# **GATWICK AIRPORT NORTHERN RUNWAY PROJECT**

### **Comments on The Applicant's Response To The ExA's Written Questions (ExQ1)**

#### **Response to [\[REP3-095\]](#) | Historic Environment**

**DEADLINE 4: 15 May 2024**

Figure 13. Indicative Site Plan - Car park X Deck Parking

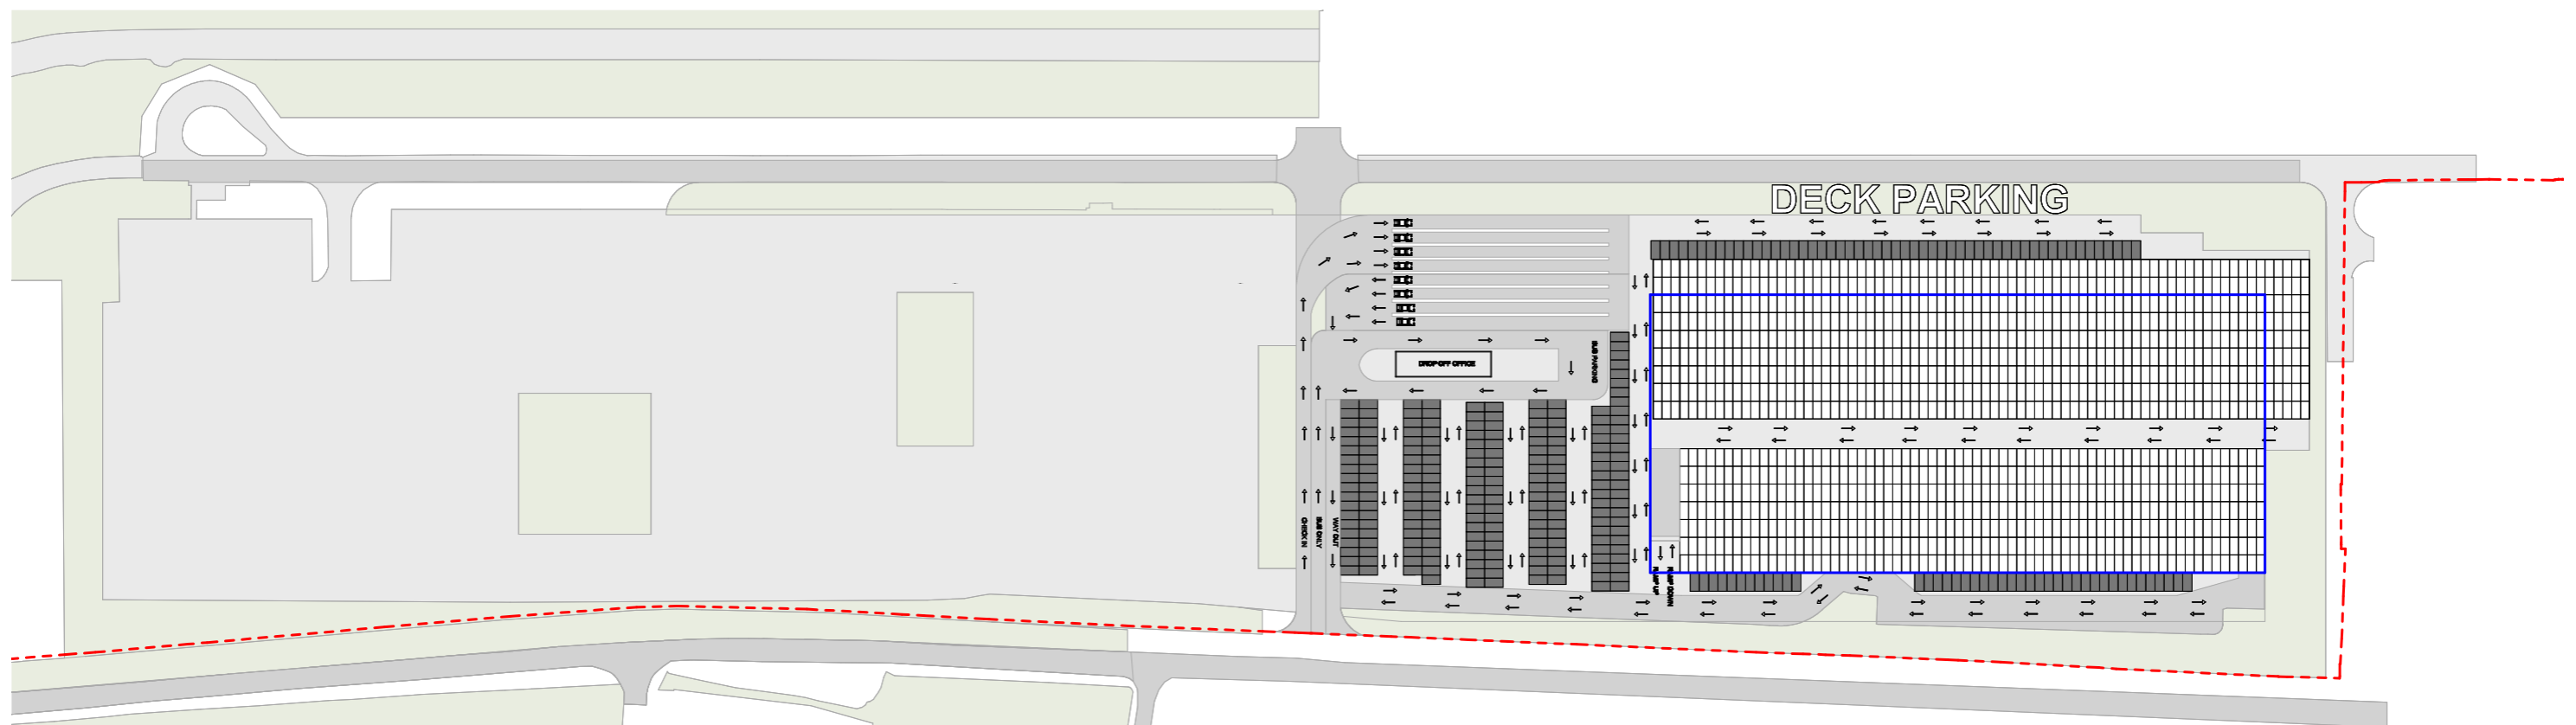
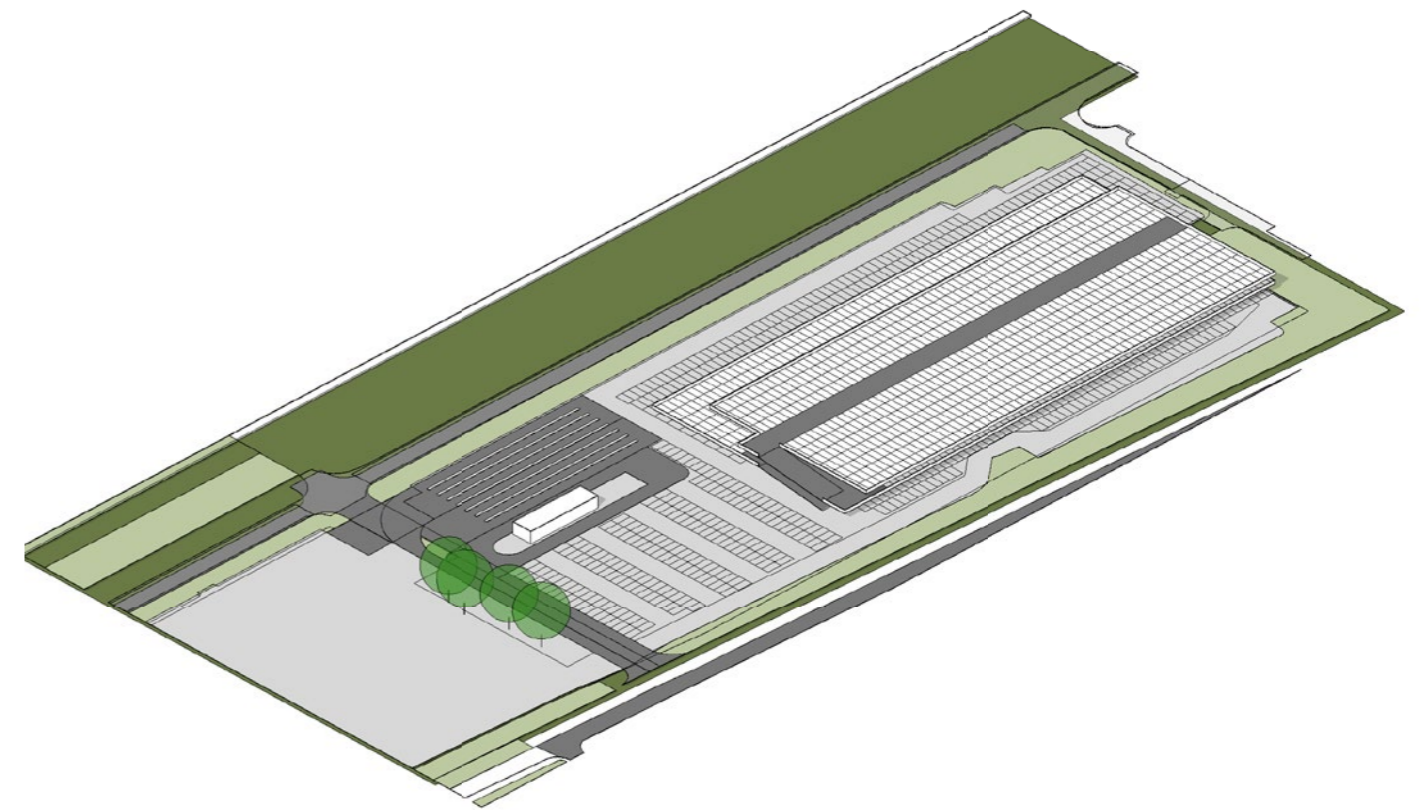
<p>structures at the proposed Car Park X, including an assessment of light spill on the setting of the heritage asset.</p>	<p>While the Applicant states the decked car park is to the east of Works Area 31, the parameter plan shows a maximum height of development of 11 metres extending westwards beyond the new widened site access to within approximately 30m of the junction Poles Lane (the scale bar on the works plan map does not appear to be correct). This parameter drawing GA9000108 Rev P01 [AS-131] is currently proposed to be approved and is the only plan showing the extent of built form therefore the concerns about visual impact remain. The height of any works for the drainage features or lighting or fencing for the remaining western part of the site is also not specified. This extent of built form on the eastern portion of the works site is also shown on Figure 1.1.1 in the OLEMP [REP3-031]. The revised design and access principles listed as DBF9 [REP3 -056] comprising of 3 loosely worded statements which do not provide the control over the positioning of the deck park in relation to the listed building. Limiting tree and hedgerow removal where possible is welcomed but is still too loosely worded and while a commitment to replanting along the southern boundary is supported this does not go far enough as the Authorities wish to see the effective screening for the car park from not just the listed building but visual impact of the development (including any light spill) from the wider countryside to the south.</p> <p>The tree removal plan for the Car Park X Appendix 8.10.1 Sheet 12 of 13 [REP3-041] is confusing to understand as the key does not assist in identifying clearly which of the trees surveyed are being removed. The extent of tree loss along the southern boundary to form the widened access is unclear as this does not appear to correspond with the current access. The Authorities would like a clear survey drawing for this site showing individual trees (not broad groups) and clearly identifying which ones would be removed. The current drawing is not on an Ordnance Survey base and therefore the site relationship with surrounding features such as Charlwood House cannot be readily established.</p> <p>While it is noted that references to new and replacement planting for Car Park X has been included as a specific reference in the OLEMP para 3.2.3 [REP3-031] the wording is still not considered to adequately address the</p>

<p>Park Farmhouse, therefore the magnitude of impact would be no change. The indicative design information for the Car Park is contained within the <b>Design &amp; Access Statement - Volume 3</b> <a href="#">[REP2-034]</a> at section 5.6.7 and Figure 24.</p> <p>As stated in response to HE1.2 above, the <b>Design Principles</b> (Doc Ref. 7.3 v2) provides site-wide design principles for car parks including landscaping and built form related design principles. The <b>Design Principles</b> are secured by Requirement 4 of the <b>dDCO</b> (Doc Ref. 2.1 v6).</p> <p>(b) The Bear and Bunny Nursery is a longstanding occupier of the building which is owned by GAL. <b>ES Chapter 14: Noise and Vibration</b> <a href="#">[APP-039]</a> considers buildings in use as nurseries as being potentially highly sensitive and assessment is undertaken on a case by case basis. During preparation of the ES, a site visit was undertaken to the Bear &amp; Bunny Nursery (occupiers of Charlwood Park Farmhouse) and a discussion held with the managers of it. The ES assessment concluded that there would be negligible adverse effects at this receptor (see paragraphs 14.4.86, 14.9.20 and 14.9.224 of <b>ES Chapter 14: Noise and Vibration</b> <a href="#">[APP-039]</a>).</p> <p>Separately in ExQ1 NV.1.19, the ExA has asked why nurseries are not included in the Noise Insulation Scheme for schools. The Applicant has subsequently agreed to include them because some can be noise sensitive and they will be considered for insulation. The Applicant's Response to</p>
